**KIRKLEES METROPOLITAN COUNCIL
INVESTMENT & REGENERATION SERVICE**

DELEGATED DECISION TO DETERMINE PLANNING APPLICATIONS

Reference No:	2025/62/91497/E
Site Address:	52, Woodside Crescent, Staincliffe, Batley, WF17 7DY
Description:	Raising of roof height and erection of dormer windows to rear
Recommending Officer:	Jennifer Booth

DECISION - REFUSED

PROPOSED SIDE ELEVATION

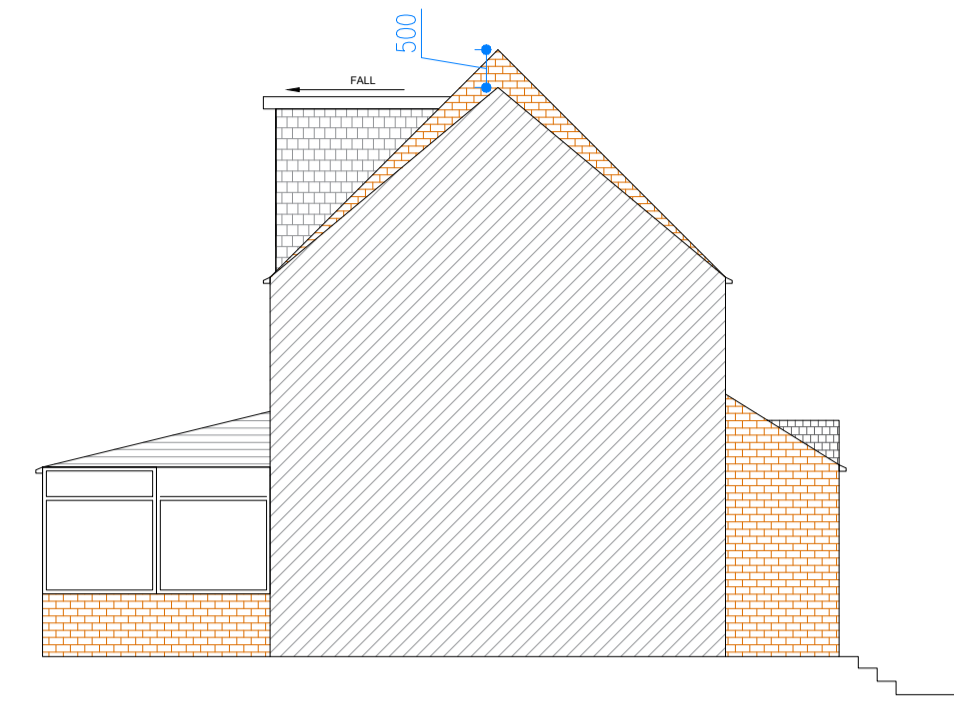
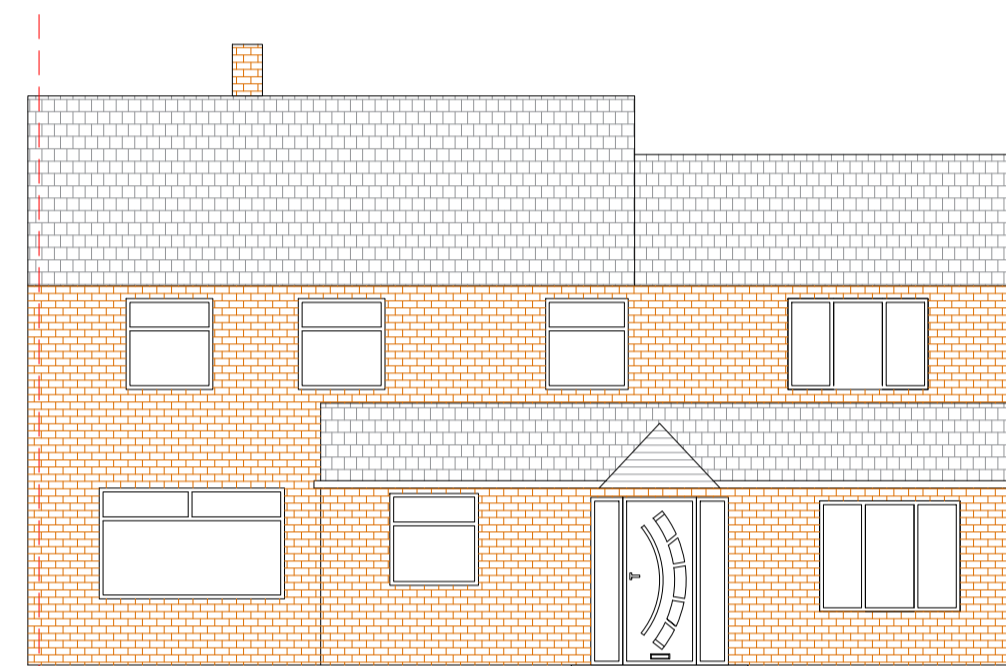
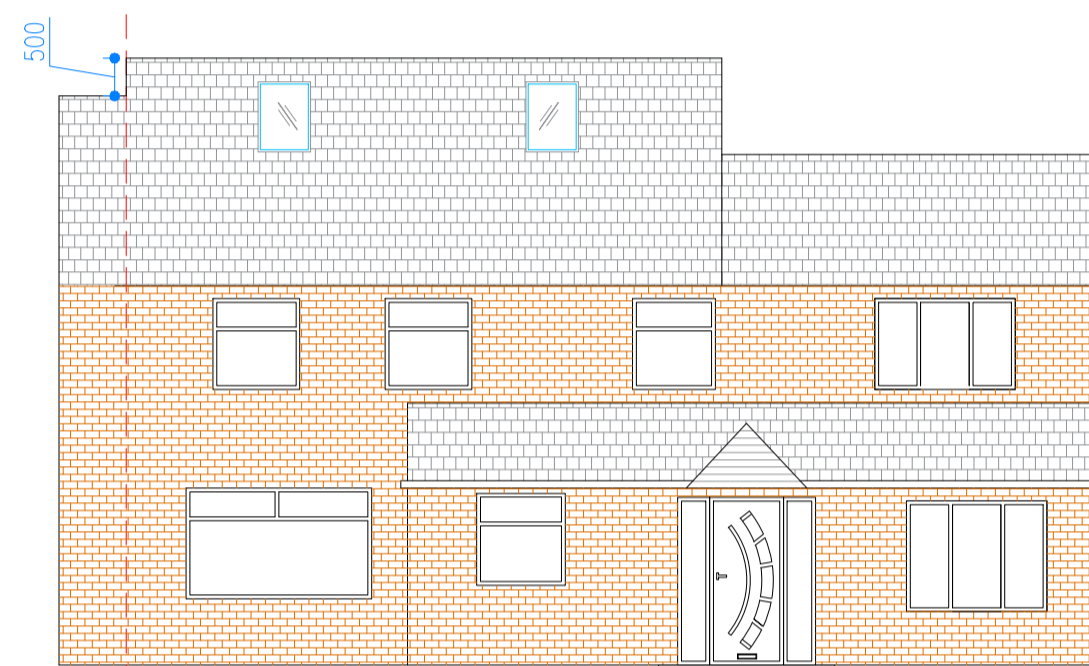
The application site forms part of a continuous row of dwellings of uniform height and consistent roofline. The proposed increase in the roof height would disrupt this uniformity, resulting in a development that would appear unduly

prominent and visually incongruous within the established street scene. As such, the proposed alteration is considered to be out of character with the surrounding built form and would result in harm to the visual amenity of the area. While the rear dormer, when considered in isolation, could be acceptable in principle, its acceptability is outweighed by the overall harm arising from the increased roof height. Therefore, the proposal is considered unacceptable in visual terms.

Having taken the above into account, the proposed increase in roof height would result in an incongruous addition that would be overly prominent within the established street scene, disrupting the uniform character and consistent roofline of the surrounding dwellings. This alteration would appear visually intrusive and out of keeping with the form, scale, and layout of the host property and its context. As such, the proposal would fail to form a subservient addition and would not respect the character of the existing building. Consequently, the development would result in significant harm to the visual amenity of both the host dwelling and the wider area. The proposal is therefore contrary to Policy LP24(a) and (c) of the Kirklees Local Plan, Key Design Principles 1 and 2 of the House Extensions & Alterations SPD, and the aims of Chapter 12 of the National Planning Policy Framework, which seek to ensure high-quality design that respects local character.

Officers have considered these comments and remain of the opinion that the proposal would introduce an increased roof height which would not be in keeping with or compliment the linear form of the terraced row or neighbouring terraced rows. The increase in height would detract from the host and surrounding properties which would be to the detriment of the visual amenity of both the host dwelling and within the immediate vicinity. As such, Officers remain concerned with the impact of proposed works and the comments received do not overcome the concerns which were relayed to the Agent.

1. The proposed increase in roof height would result in a visually intrusive and incongruous addition that disrupts the uniform character and roofline of the surrounding street scene. It fails to respect the scale, form, and layout of the host property, causing harm to the visual amenity of both the dwelling and wider area. The proposal therefore fails to comply with Policy LP24(a) and (c) of the Kirklees Local Plan, Key Design Principles 1 and 2 of the House Extensions & Alterations SPD, and Chapter 12 of the National Planning Policy Framework.

PROPOSED REAR ELEVATION

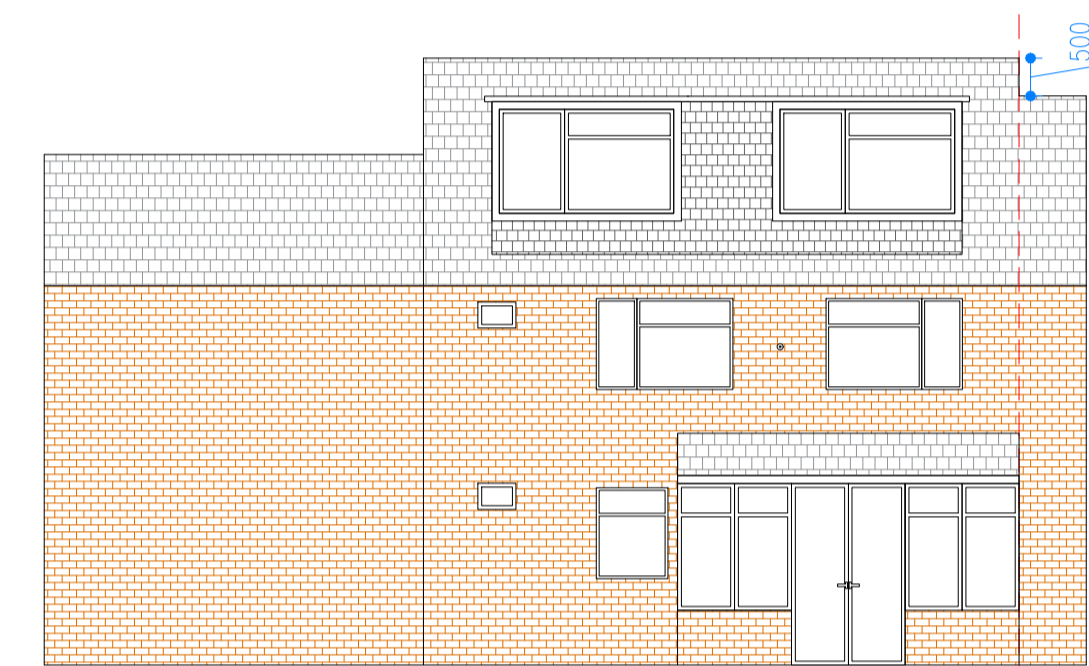
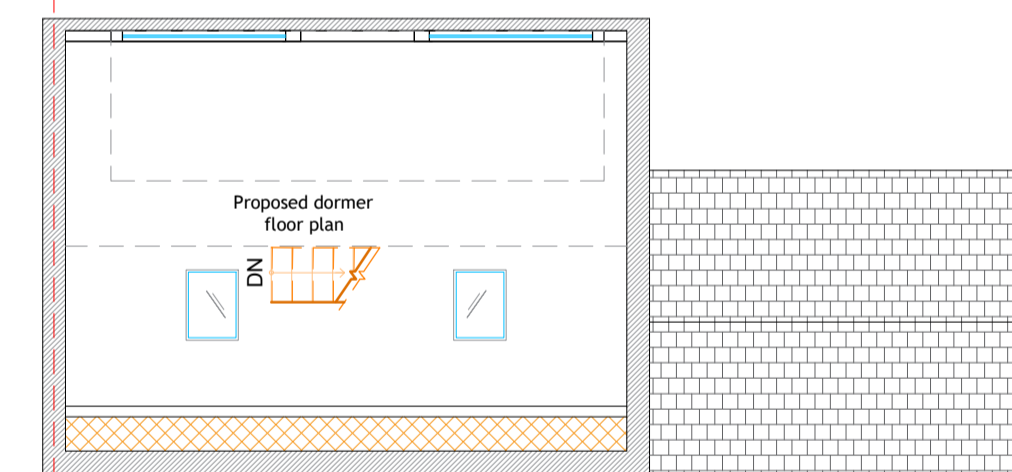
The proposed dormer extension would be located within the same roof structure as that to be extended in height and would be a width of 6.2 metres, height of 2 metres and would be set within the proposed roof form. The dormer face and cheeks would be to match the existing roof.

The proposed 0.5m increase in roof height is considered to be modest and would not result in any significant harm to the residential amenities of neighbouring occupiers in terms of overbearing impact or loss of light. The roof lights proposed within the front roof plane would not afford any direct views into neighbouring properties due to their angled positioning and the degree of separation from adjacent dwellings. To the rear, the proposed dormer windows would overlook the rear gardens of neighbouring properties; however, this relationship is typical of two-storey residential development and reflects the existing first-floor rear-facing windows. As such, the level of overlooking would not be materially different from the current situation, and the proposal is not considered to result in any unacceptable loss of privacy or amenity to neighbouring residents.
